**EPC STORMWATER REVIEW COMMENTS
 IN ORANGE BOXES WITH BLACK TEXT**

EL PASO COUNTY STORMWATER MANAGEMENT PLAN CHECKLIST

EPC Project Number: CDR2411

EC-1

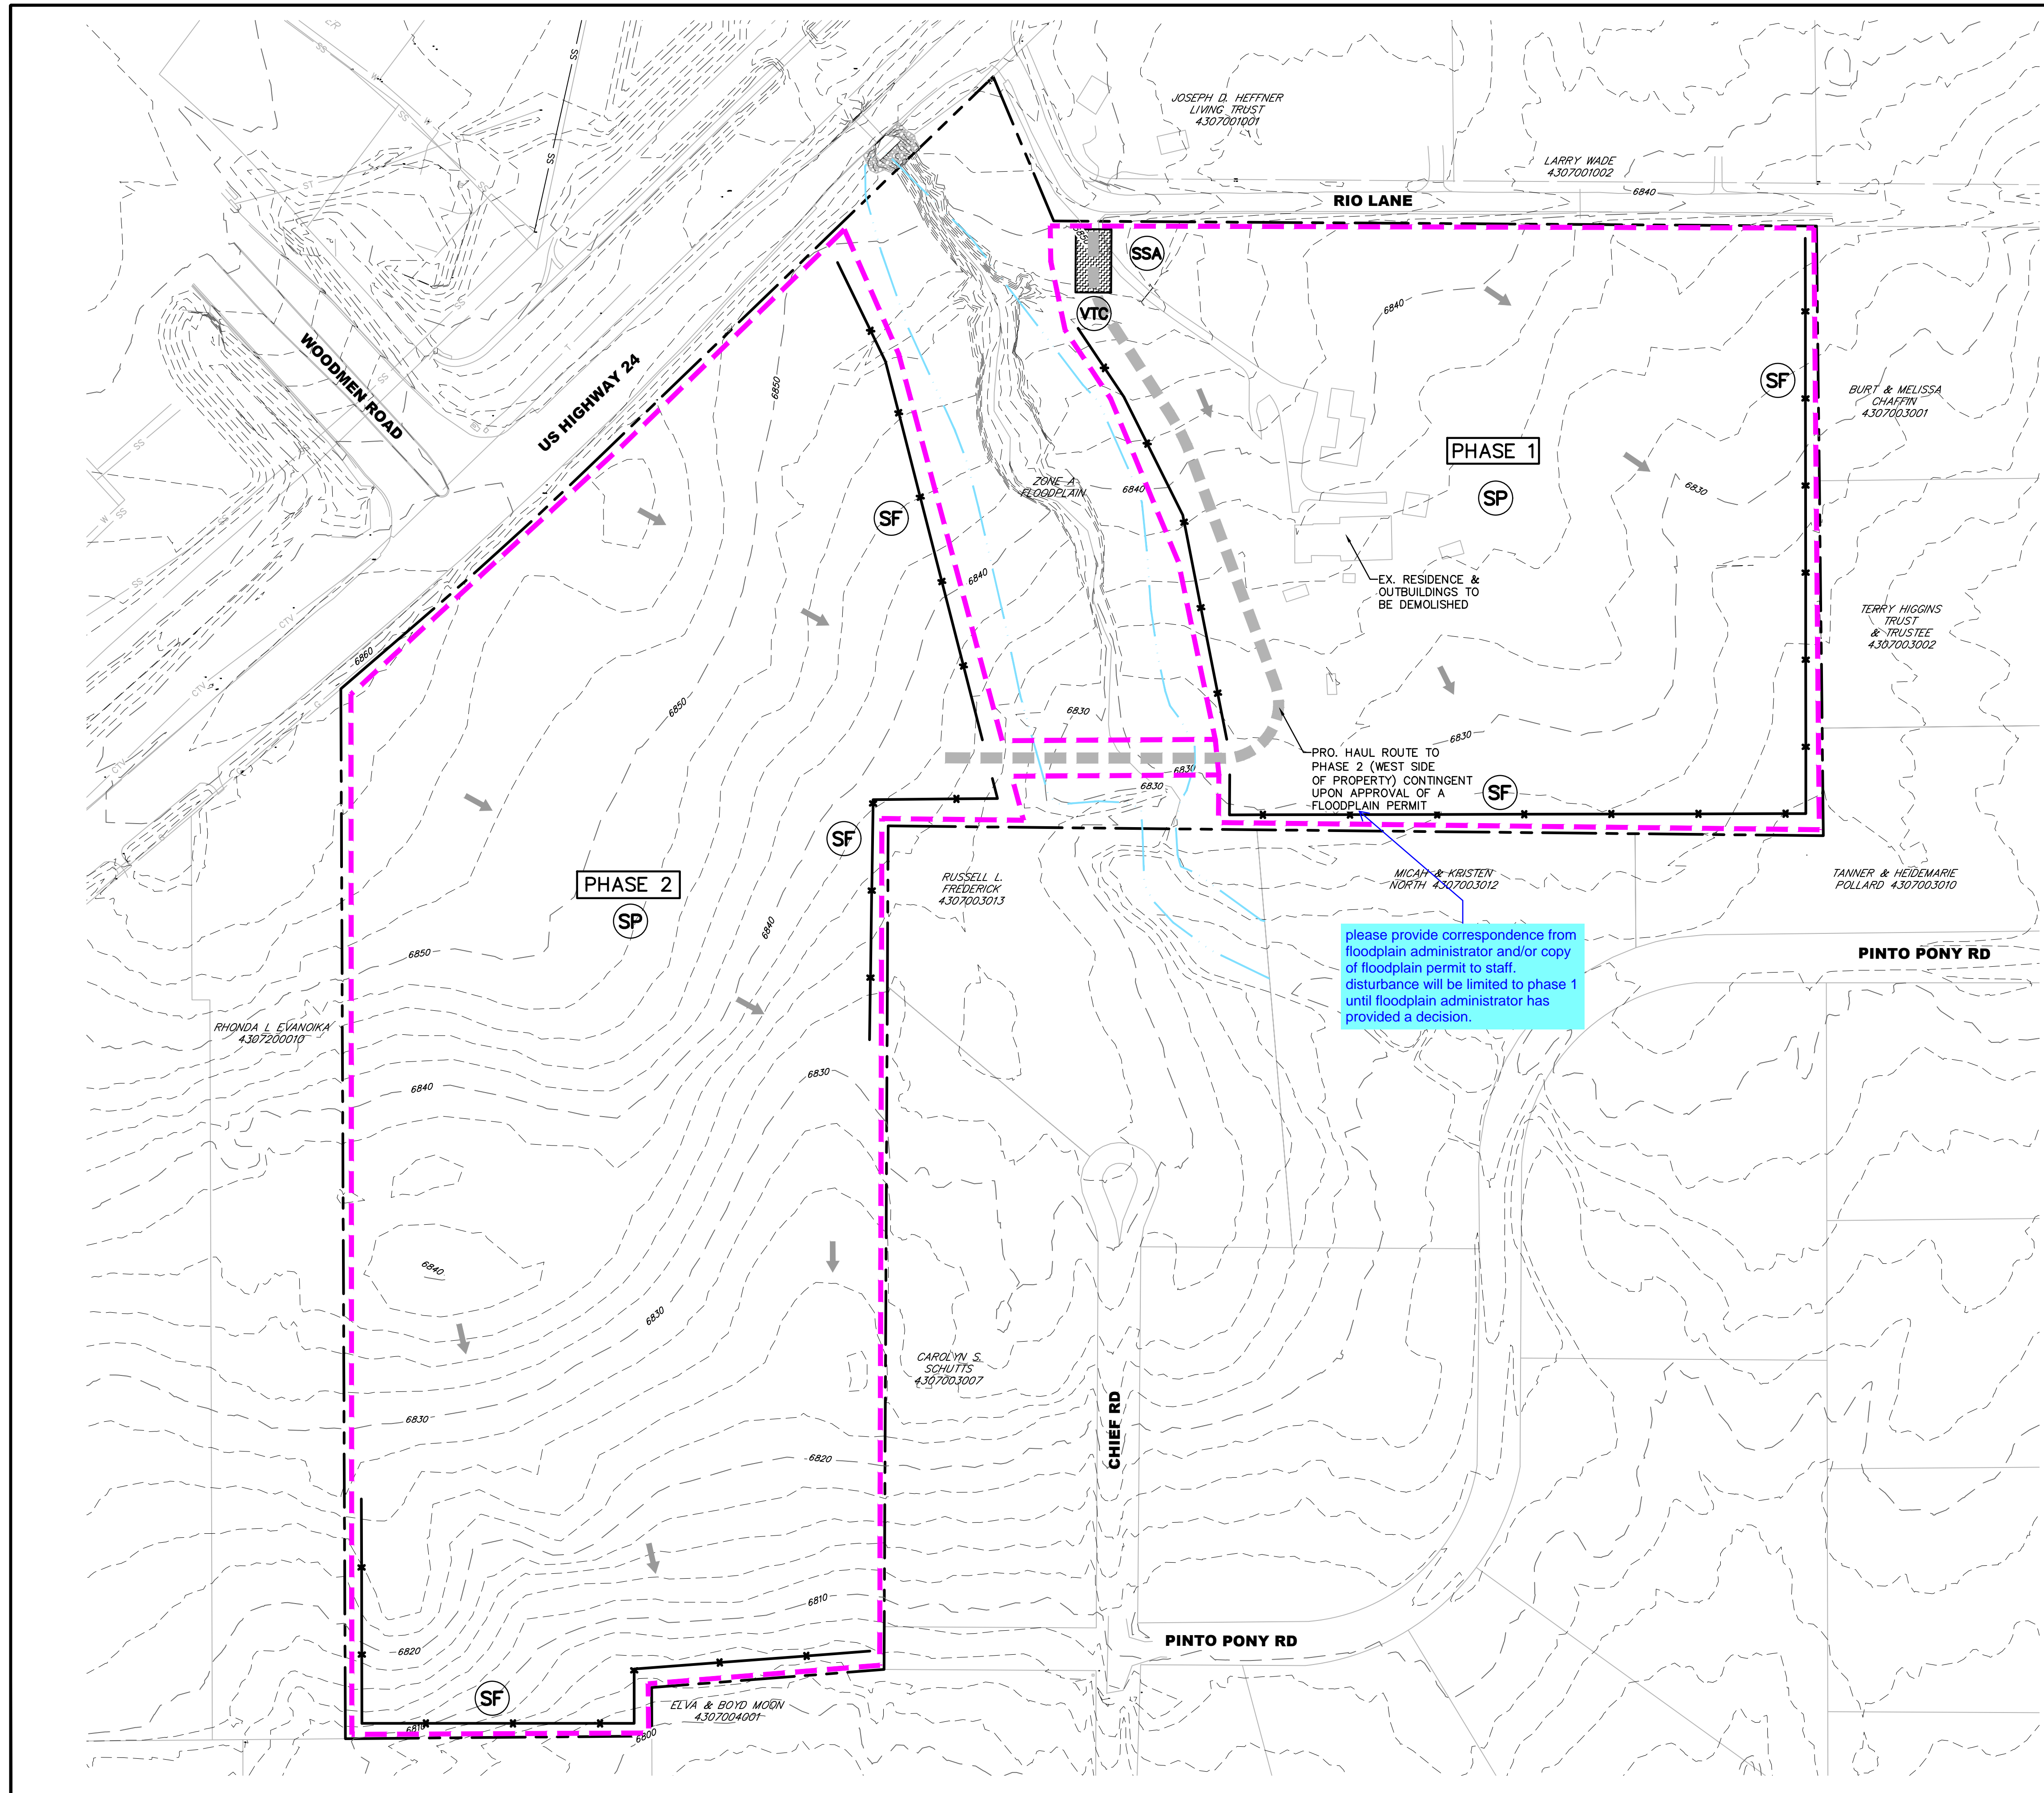
Applicant	EPC
17	SWMP Map to include: See GEC Plan Comments		
17a	construction site boundaries		Y
17b	flow arrows to depict stormwater flow directions		Y
17c	all areas of disturbance		Y
17d	areas of cut and fill		Y
17e	areas used for storage of building materials, soils (stockpiles) or wastes		N
17f	location of any dedicated asphalt / concrete batch plants		Y
17g	location of all structural control measures		N
17h	location of all non-structural control measures		N
17i	springs, streams, wetlands and other surface waters, including areas that require maintenance of pre-existing vegetation within 50 feet of a receiving water		Y
18	Narrative description of all structural control measures to be used. Modifications to EPC standard control measures must meet or exceed County-approved details		N
19	Description of all non-structural control measures to be used including seeding, mulching, protection of existing vegetation, site watering, sod placement, etc.		Y

20	Technical drawing details for all control measure installation and maintenance; custom or other jurisdiction's details used must meet or exceed EPC standards See GEC Plan comments.		N
21	Procedure describing how the SWMP is to be revised		Y
22	Description of Final Stabilization and Long-term Stormwater Quality (describe nonstructural and structural measures to control SW pollutants after construction operations have been completed, including detention, water quality control measure etc.)		N
23	Specification that final vegetative cover density is to be 70% of pre-disturbed levels		N
24	Outline of permit holder inspection procedures to install, maintain, and effectively operate control measures to manage erosion and sediment		Y
25	Record keeping procedures identified to include signature on inspection logs and location of SWMP records on-site		Y
26	If this project relies on control measures owned or operated by another entity, a documented agreement must be included in the SWMP that identifies location, installation and design specifications, and maintenance requirements and responsibility of the control measure(s)		Y
